From: James Cording [REDACTED]
Sent: 17 December 2021 08:23
To: Anita Gardner <Anita.Gardner@arun.gov.uk>
Subject: RE: LU/350/21/PL - Solar Panels, Units 33-36 on Land at Lineside Industrial Estate

From: Anita Gardner [<mailto:Anita.Gardner@arun.gov.uk>]
Sent: 15 December 2021 17:18
To: James Cording [REDACTED]
Subject: LU/350/21/PL - Solar Panels, Units 33-36 on Land at Lineside Industrial Estate

Drawing No.	Rev.
19005 - TP - 010	-

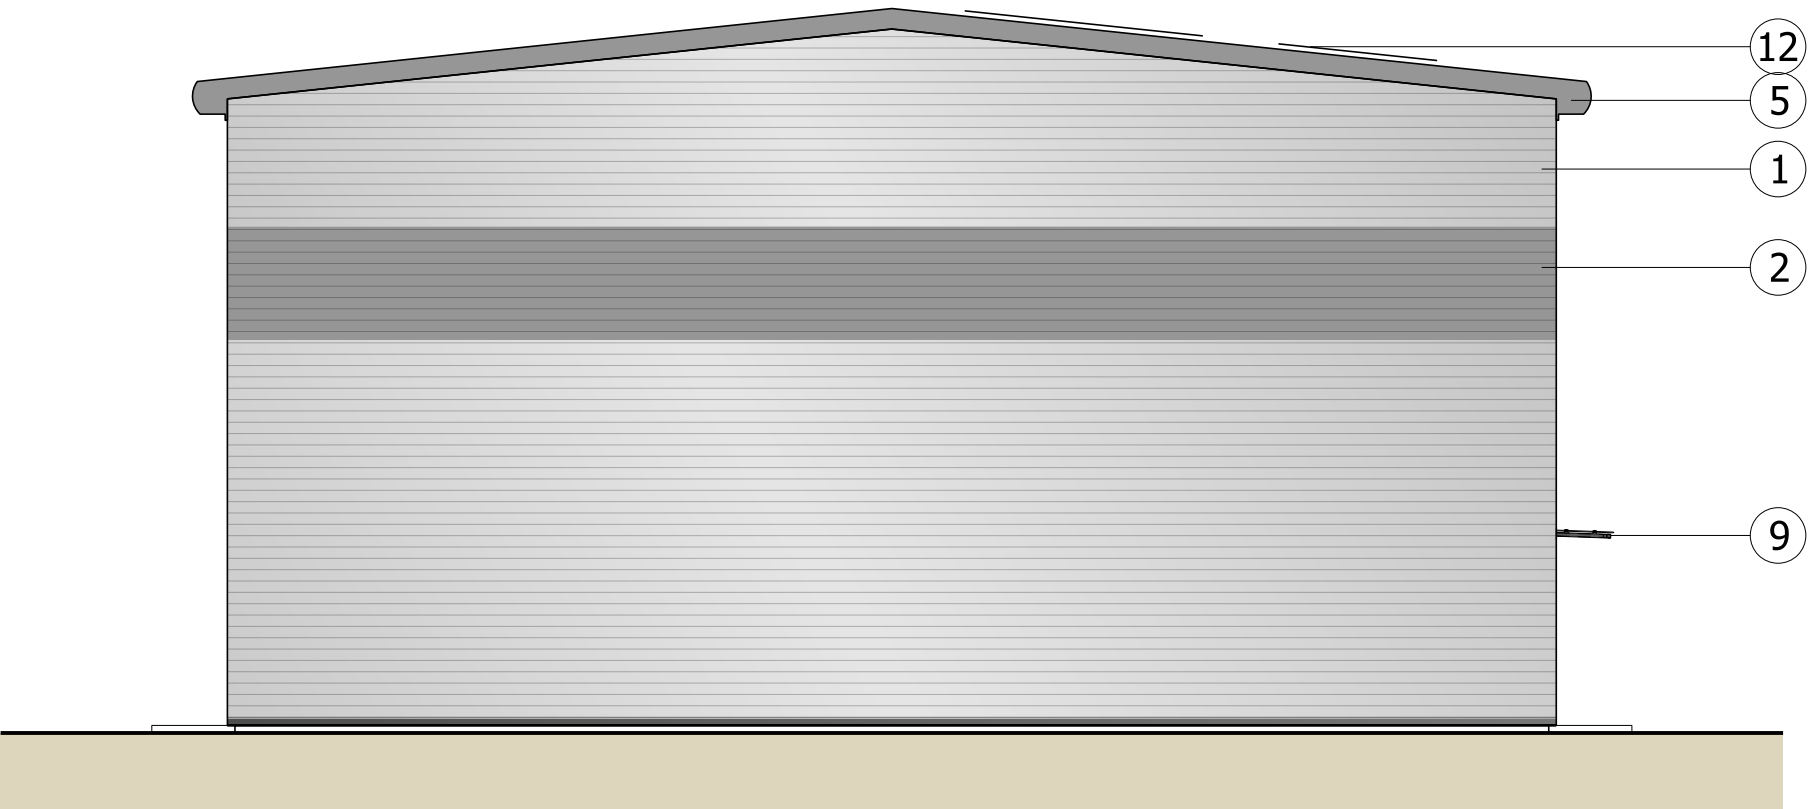
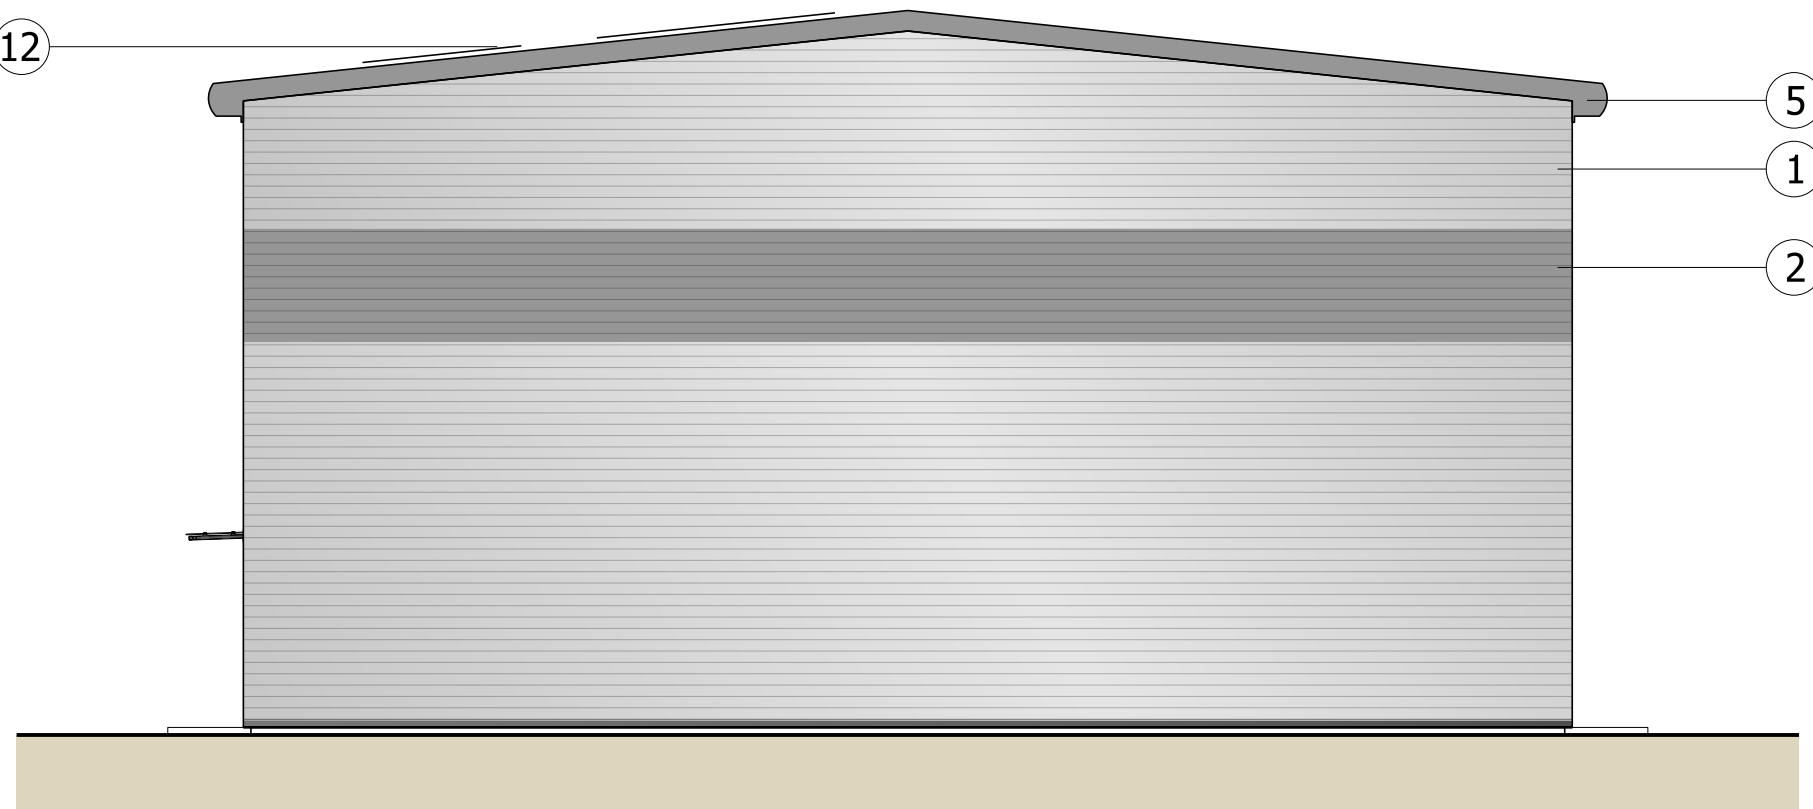
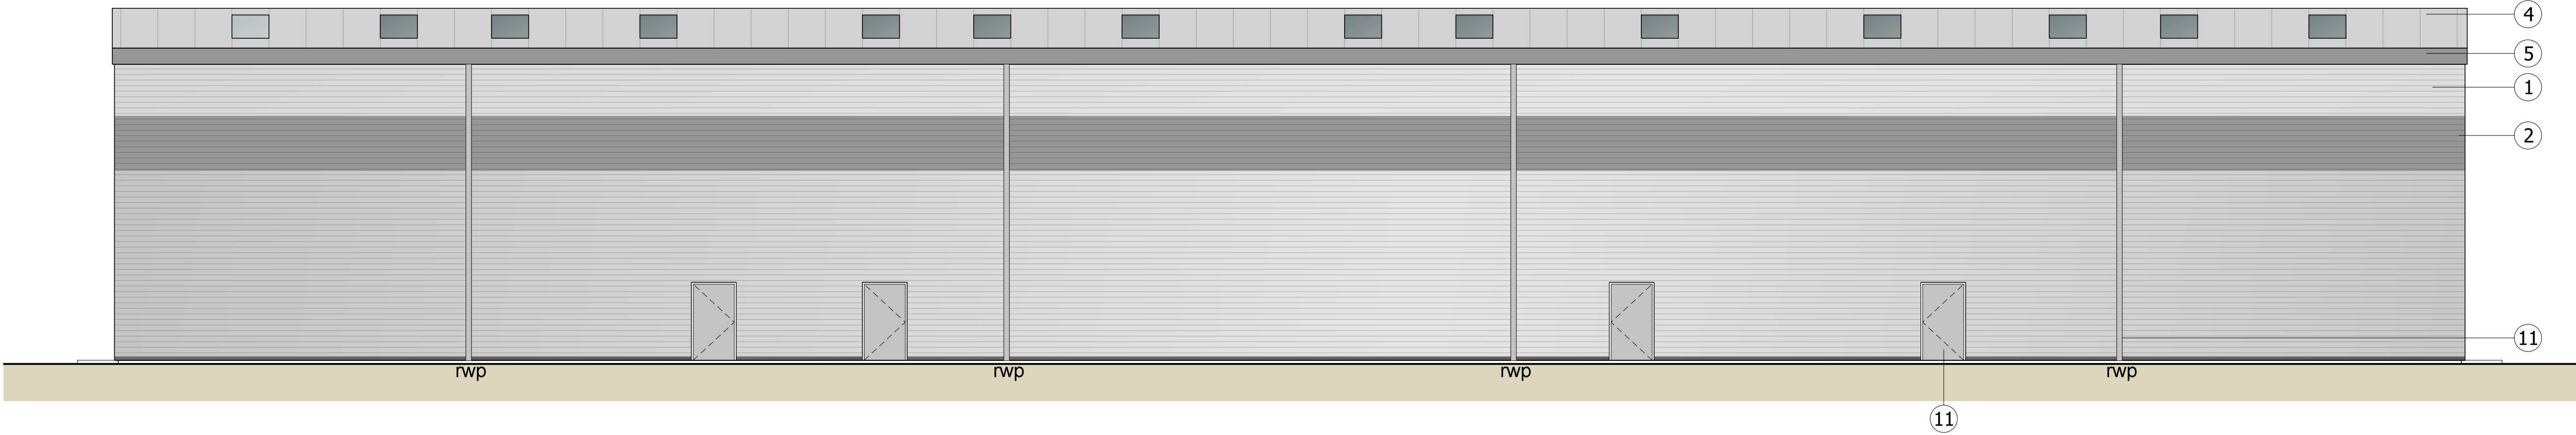
I am about to start writing the officer report for the above planning application and note that there are no elevation plans provided. These will be required to demonstrate the projection from the roof of the panels. Please can you let me have these additional plans by the end of this week if possible. I would like to be in a position to provide you with a decision before the Christmas break.

It should be noted that the proposed PV panels do not sit more than 70mm above the roof plane so it may be a little difficult to observe the PV panels on the North and South Elevations at the 1:100 scale but nevertheless they are there.
